Final Report - Corrections Required
Application No. ANEX-23-0014

Description : A request by Norris Ranch Joint Venture, LLC, for annexation of 19.605 acres into the City of Colorado Springs. The annexation is a part of the overall Karman Line Land Use Plan, which is being submitted concurrently. The Land Use Plan proposes a maximum of 6,500 dwelling units, approximately 45 acres of light industrial, 105 acres of commercial/retail, 100 acres of mixed-use development, and 570 acres of park/open space.

Document Filename : KARMAN VICINITY MAPS 2023-03-27.pdf

**NOTE:**  
This EXHIBIT does not represent a monumented land survey, and is only intended to depict the attached LEGAL DESCRIPTION.

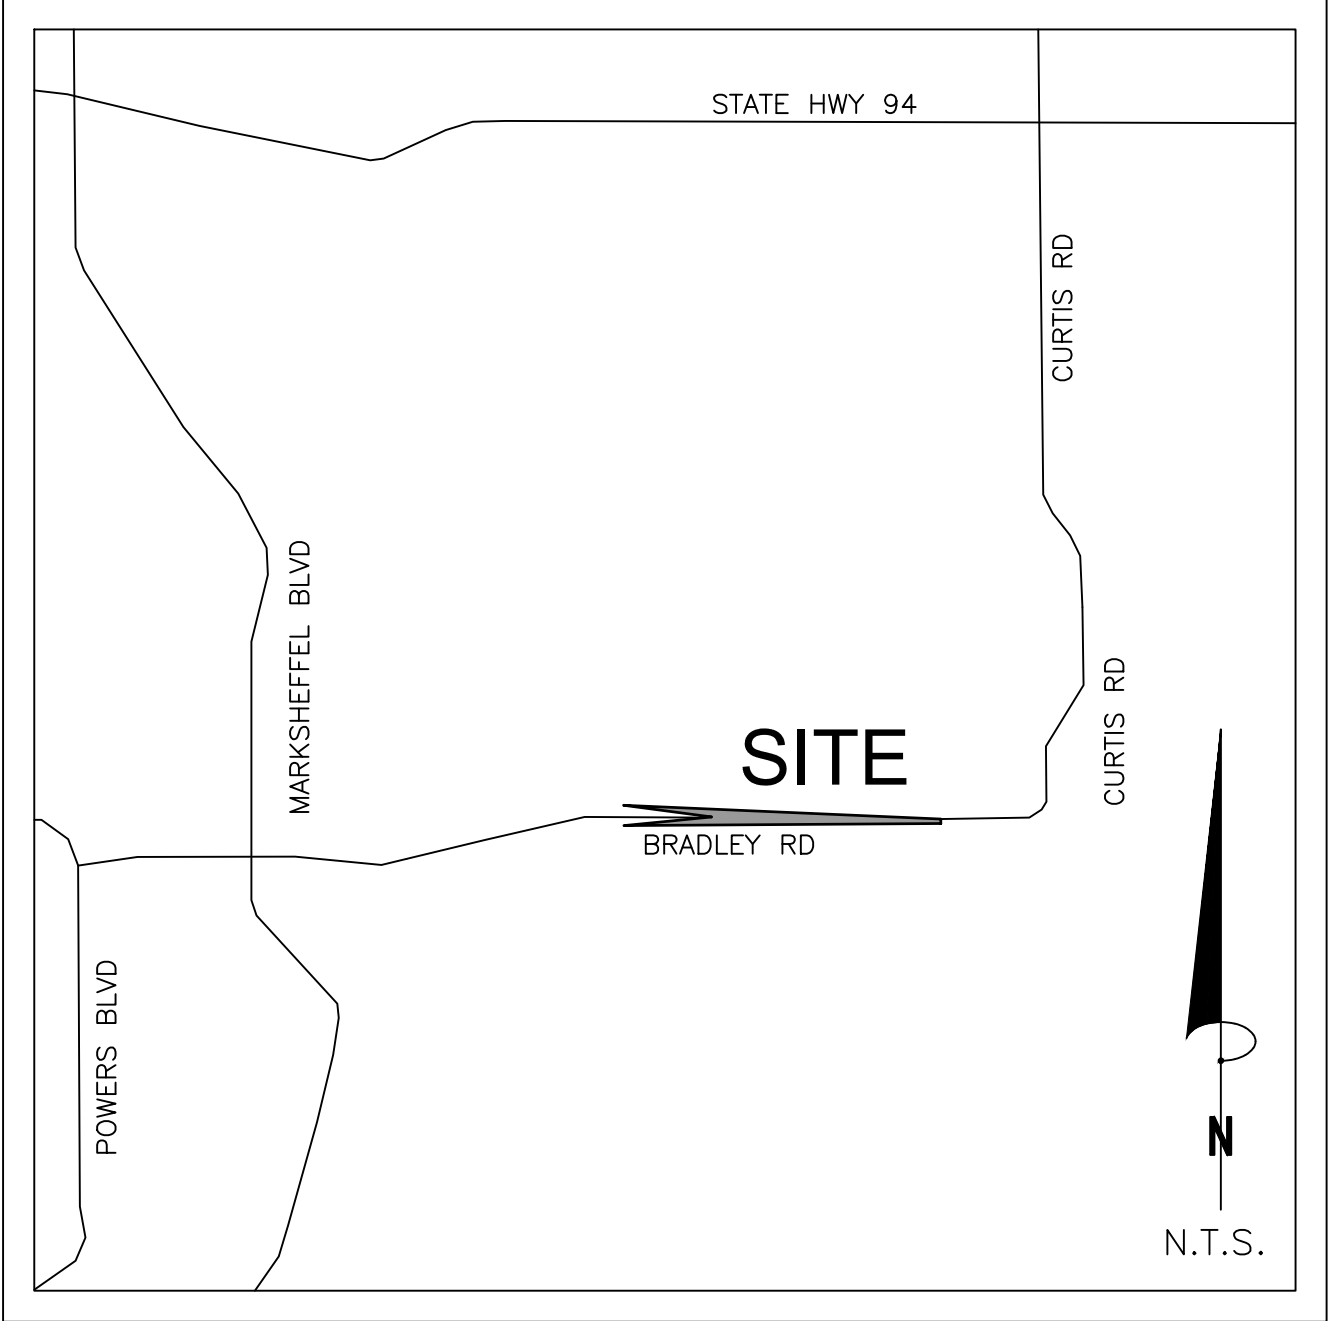
Comment ID	Page Reference	Author : Department	Review Comments
29	6	Dan Sexton : Planning	In addition to the already provided vicinity maps for each annexation plan that is part of the serial annexation request, please provide an overall vicinity map that depicts all of the area to be annexed.
